Your Ref: OWPC96
Our Ref: R/68/13/ 19-03-2013
Please ask for:
Mr J Smith

Side and rear extension
32 Tennyson Avenue Rustington

Thank you for your internet representation made on 13th April 2013 which has been recorded as **'an objection'** with the comments as follows:

PROPOSED FRONT ELEVATION

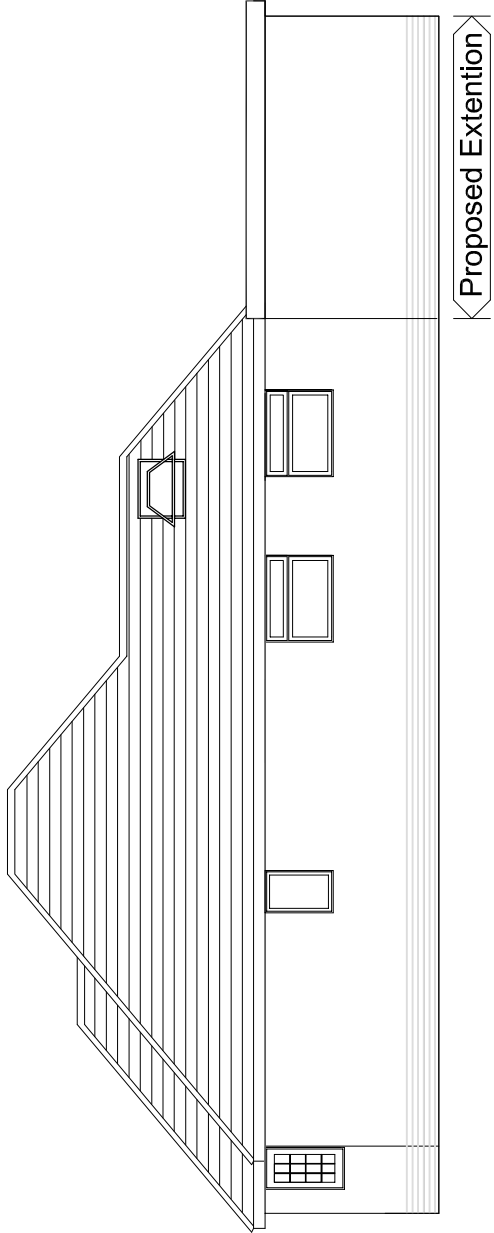
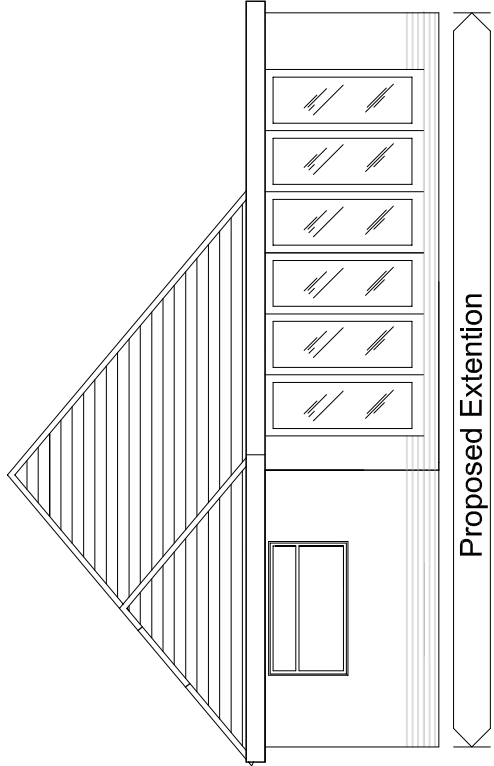
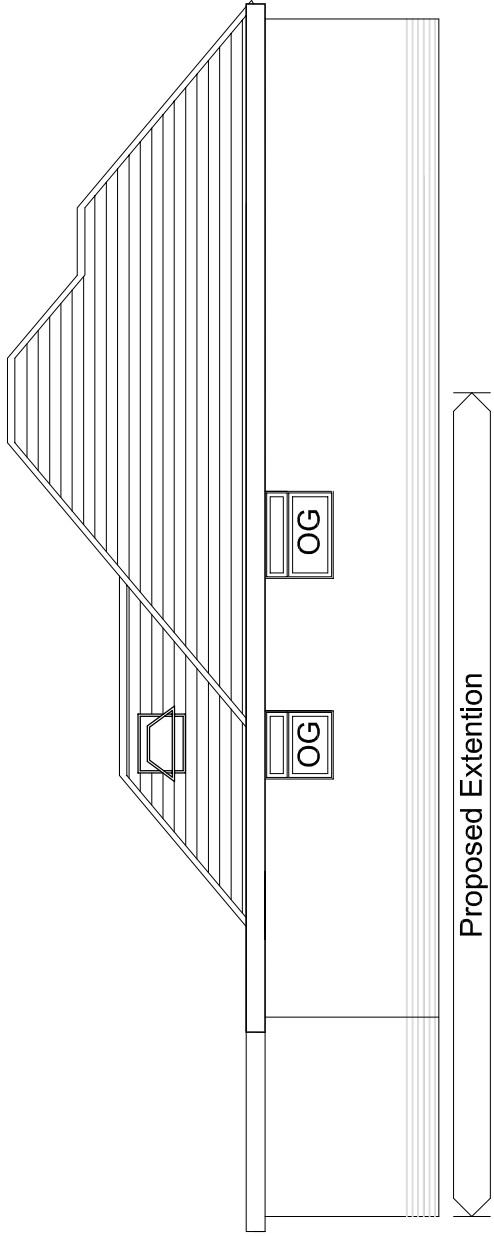
The existing garage at No.32 is currently built up to the boundary fence with No.34, and less than 1 metre from No.34 property. The guttering encroaches over the boundary fence, and the roof is sloping to some 30cm lower than the proposed front elevation on the plan shows.

This elevation also shows the extension to fit under the soffit whereas the other three proposed elevations show the extension to be some distance above it.

My objection is that the garage roof and side extension roof would be raised by some 50+cm, and that the guttering would encroach over the boundary along the length of the garage and side extension (which would extend beyond the rear of No. 34). I am also concerned that the windows would overlook the kitchen, bathroom and bedroom/study of No.34.

The closeness, length and increased height of the side extension would create a loss of light and impaired outlook, and the windows would cause a loss of privacy. As a whole, the side pathway for No34 would become too overbearing to use.
